Appeal Decision

Appeal Ref: APP/R5510/X/24/3337784

31 Greenacres Avenue, Ickenham, Uxbridge UB10 8HQ

Ground floor plan

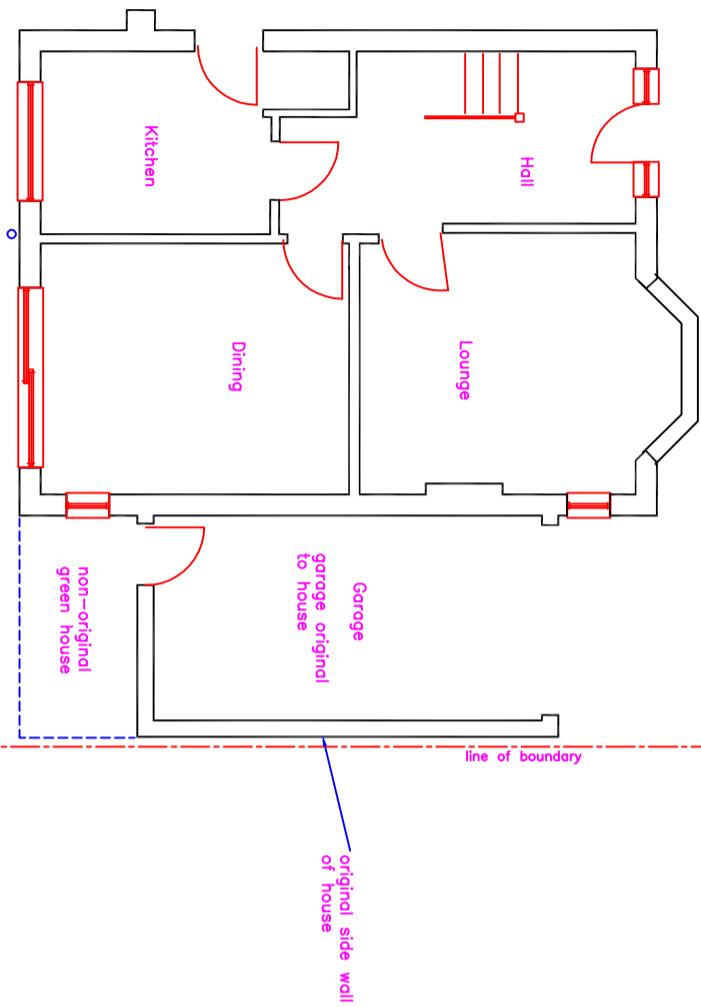
4. Development is also not permitted under Class A, as set out in paragraph A.1 if, amongst other things, (j) the enlarged part of the dwellinghouse would extend beyond a wall forming a side elevation of the original dwellinghouse and would, amongst other things, have a width greater than half the width of the original dwellinghouse. The rear elevation of the original dwellinghouse is staggered because the rear elevation of the garage is set back from the rear elevation of the dwelling. The proposed extension, which would extend across the whole width of the rear of the original dwellinghouse, would therefore extend beyond the side wall of the dwellinghouse between the rear

elevations of the dwelling and the garage. The width of the proposed extension would be greater than half the width of the original dwellinghouse and the extension would not therefore accord with paragraph A.1(j).

5. The Government has published Technical Guidance to Part 1 of Schedule 2 of the GPDO. This guidance confirms that "Where an extension is beyond any side wall, the restrictions in (j) will apply". The proposed extension would not satisfy the restrictions of paragraph A.1(j) and would not thus be development permitted under Class A of Part 1 of Schedule 2 of the GPDO.
